Outline application, with all matters reserved, for residential development with associated open space, landscaping, drainage infrastructure, acoustic mitigation, and associated works. Land at, Eastfield, Shepley, Huddersfield, HD8 8HB

Reference 2025/92776

Figure 4-2 Knowle Park Avenue Proposed Southbound only arrangement

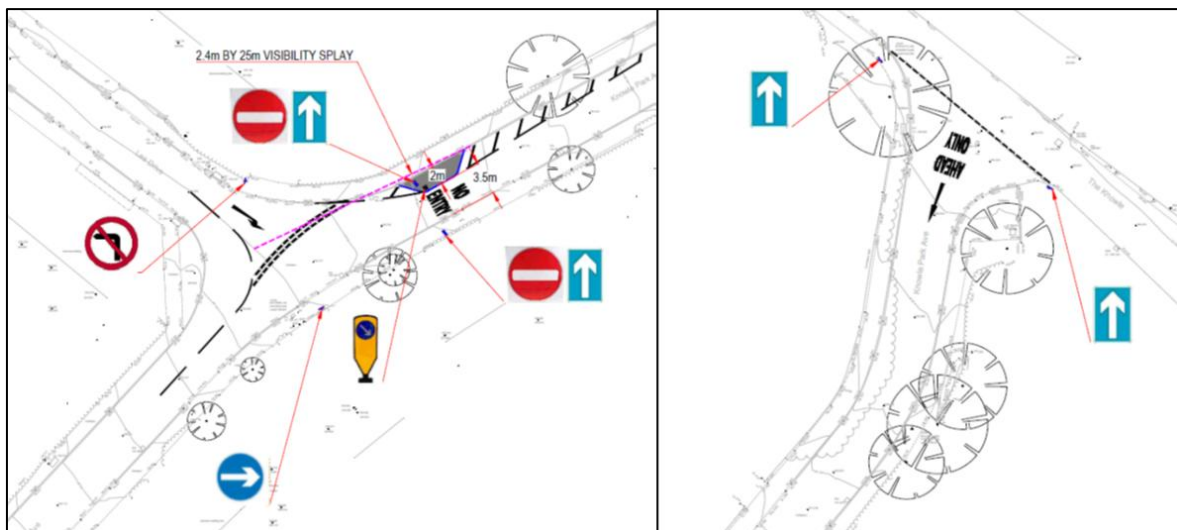
The proposal would increase traffic using Lea Drive to enter Abbey Road South and the Transport Assessment doesn't appear to assess this junction. The oneway proposal would require a Traffic Regulation Order (TRO) and this is a separate legal process to planning.

The success of a TRO cannot be relied upon for planning purposes as it involves consultations with emergency services, local councillors and local residents, where there is opportunity to formally object to the TRO. Objections would require resolution and given the potential for objection from local residents, there must be a significant chance that success of a TRO would be in jeopardy.

Drawing:
PROPOSED HIGHWAY IMPROVEMENTS - LEA DRIVE / ABBEY ROAD JUNCTION

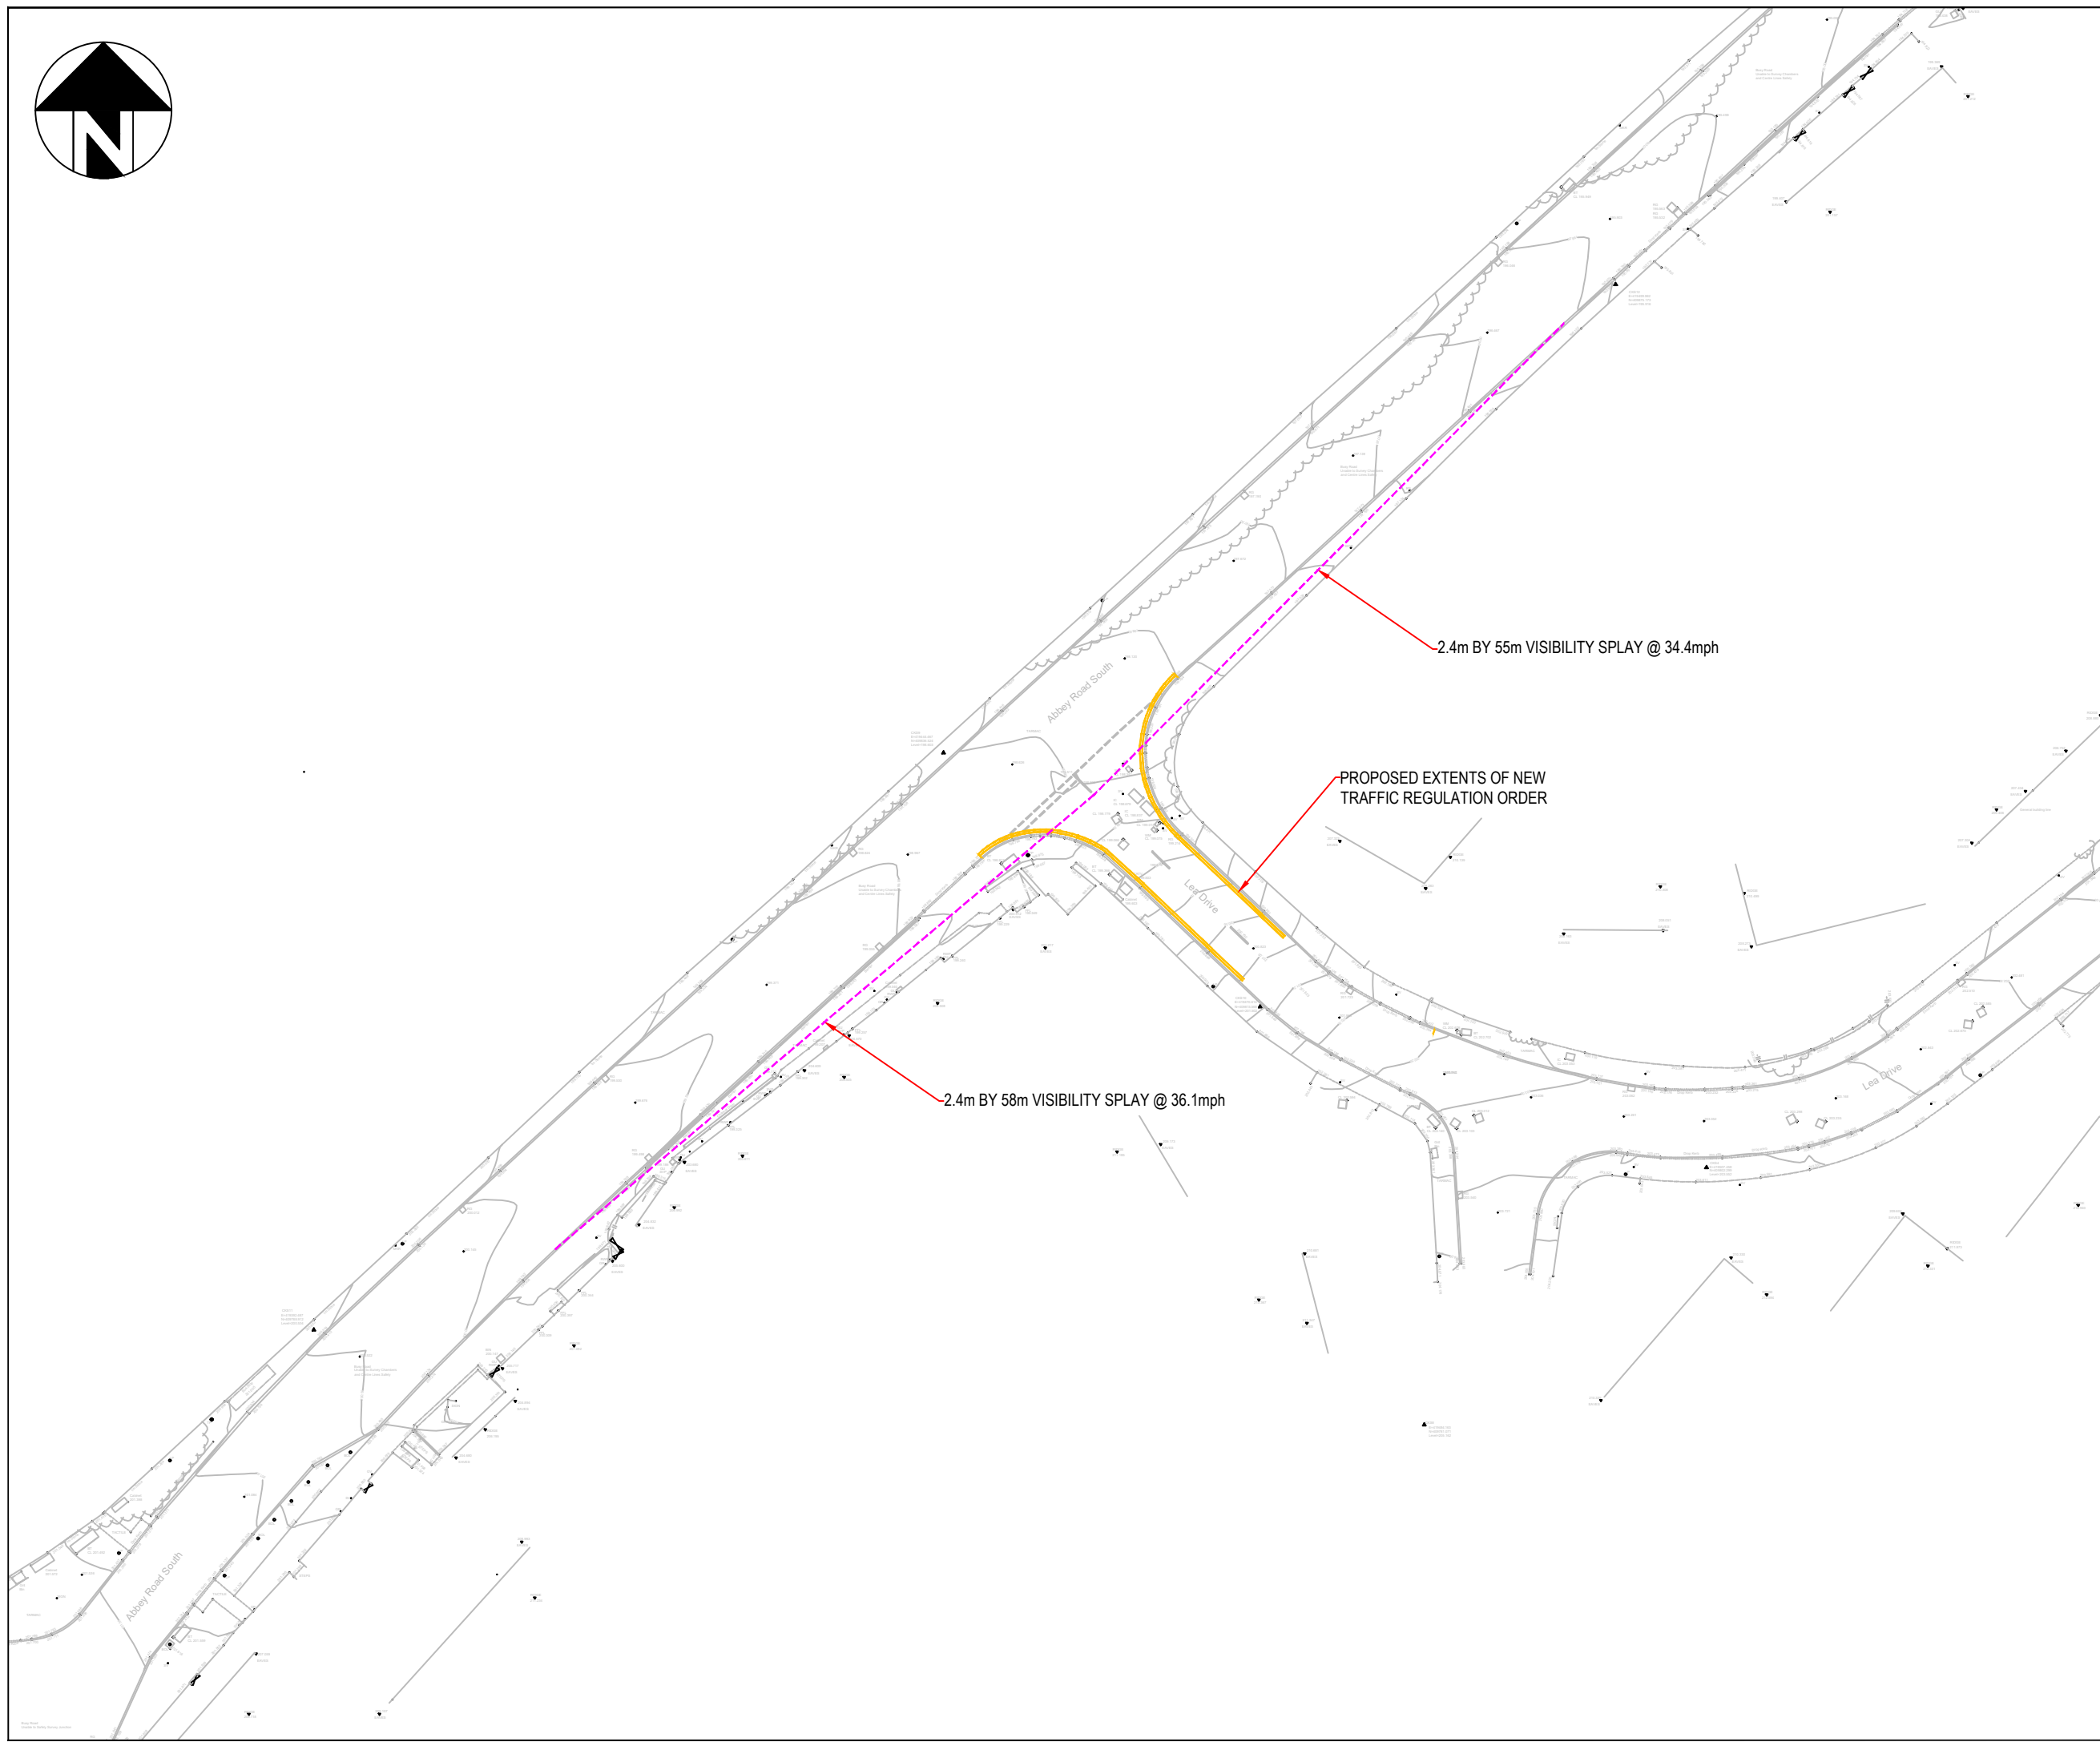
I would question how Lea Drive and Abbey Road South have been assessed, including the presence of on street parking. However, the Knowle appears totally inappropriate to use as access.
